from  
**Southern  
Water**

Your ref  
BR/280/19/PL

**Proposal:** Redevelopment of existing retail site to a mixed-use development comprising a single ground floor retail unit with 5 residential units at first, second and third floor levels.

**Site:** BR/280/19/PL: - 5 Victoria Drive, Bognor Regis, PO21 2RH

DRAWING TITLE
EXISTING SITE LAYOUT

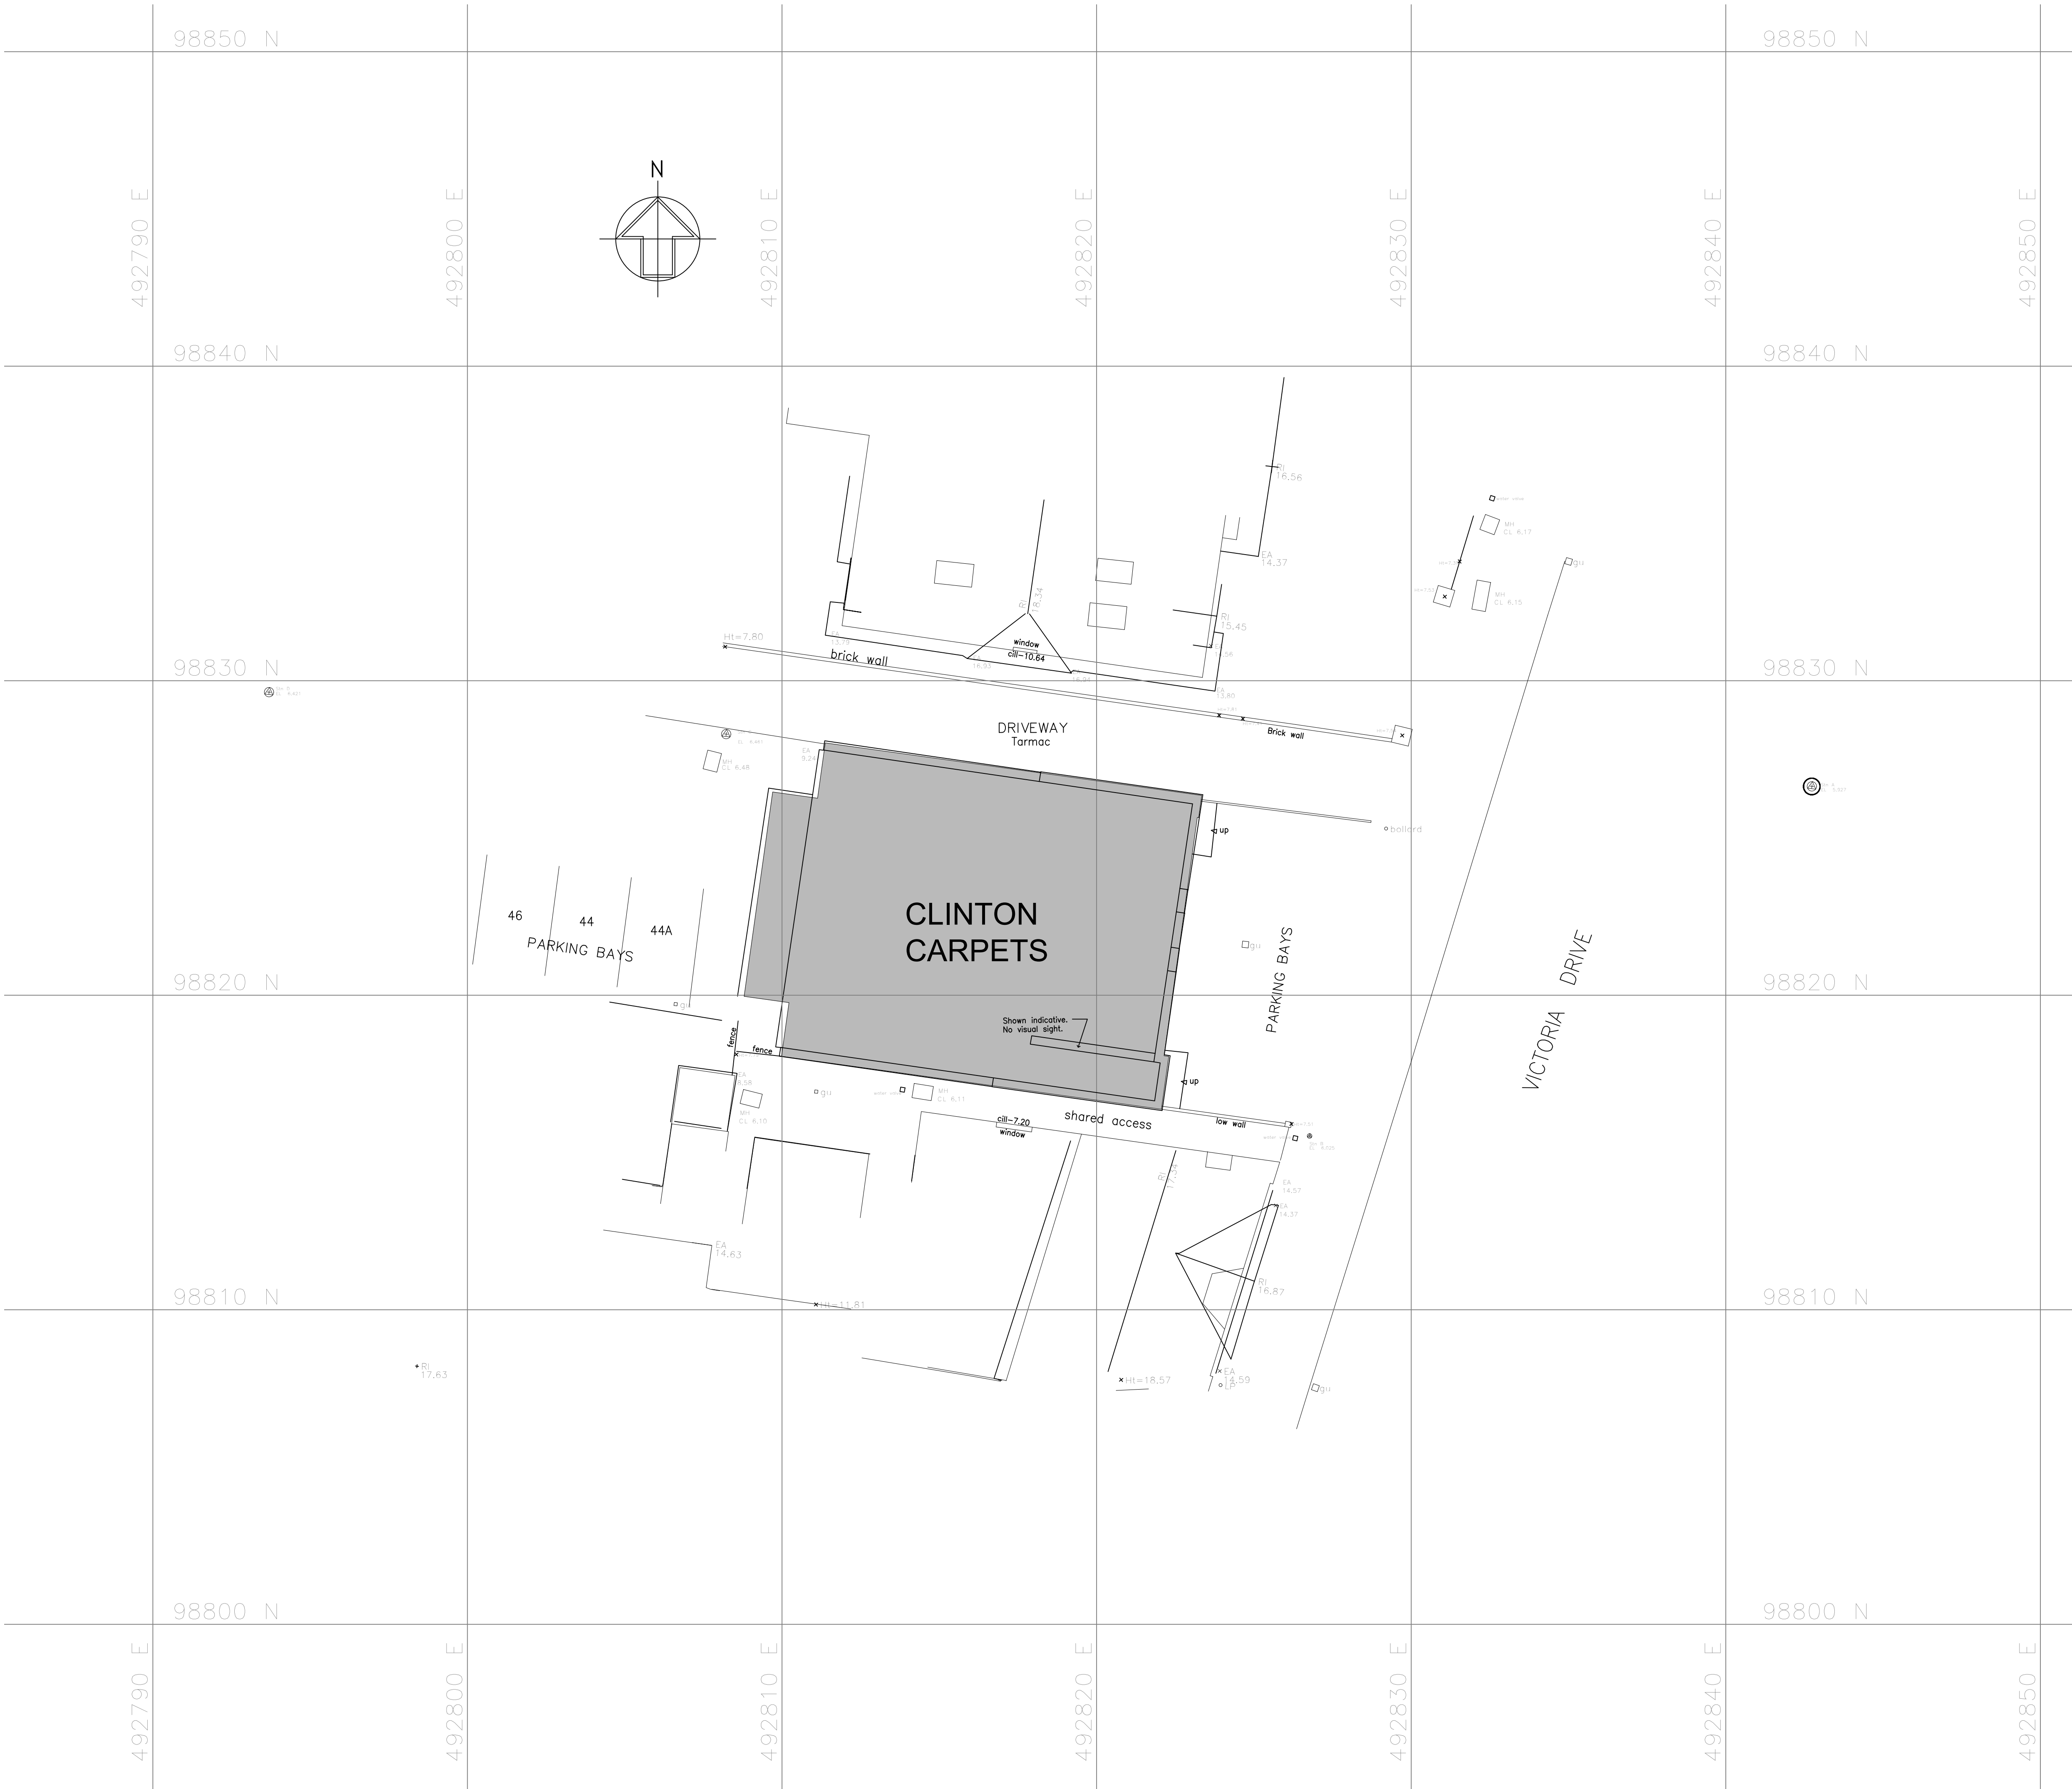
The attached plan shows that the proposed development will lie over an existing public foul sewer which will not be acceptable to Southern Water. The exact position of the public sewer must be determined on site by the applicant before the layout of the proposed development is finalised.

- The public foul sewer requires a clearance of 3 metres on either side of the gravity sewer to protect it from construction works and to allow for future access for maintenance.
- No development or tree planting should be carried out within 3 metres of the external edge of the public gravity sewer without consent from Southern Water.
- No new soakaways should be located within 5 metres of a public sewer.
- All existing infrastructure should be protected during the course of construction works.

It might be possible to divert foul sewer, so long as this would result in no unacceptable loss of hydraulic capacity, and the work was carried out at the developer's expense to the satisfaction of Southern Water under the relevant statutory provisions.

Alternatively, the applicant may wish to amend the site layout, or combine a diversion with amendment of the site layout. If the applicant would prefer to advance these options, items above also apply.
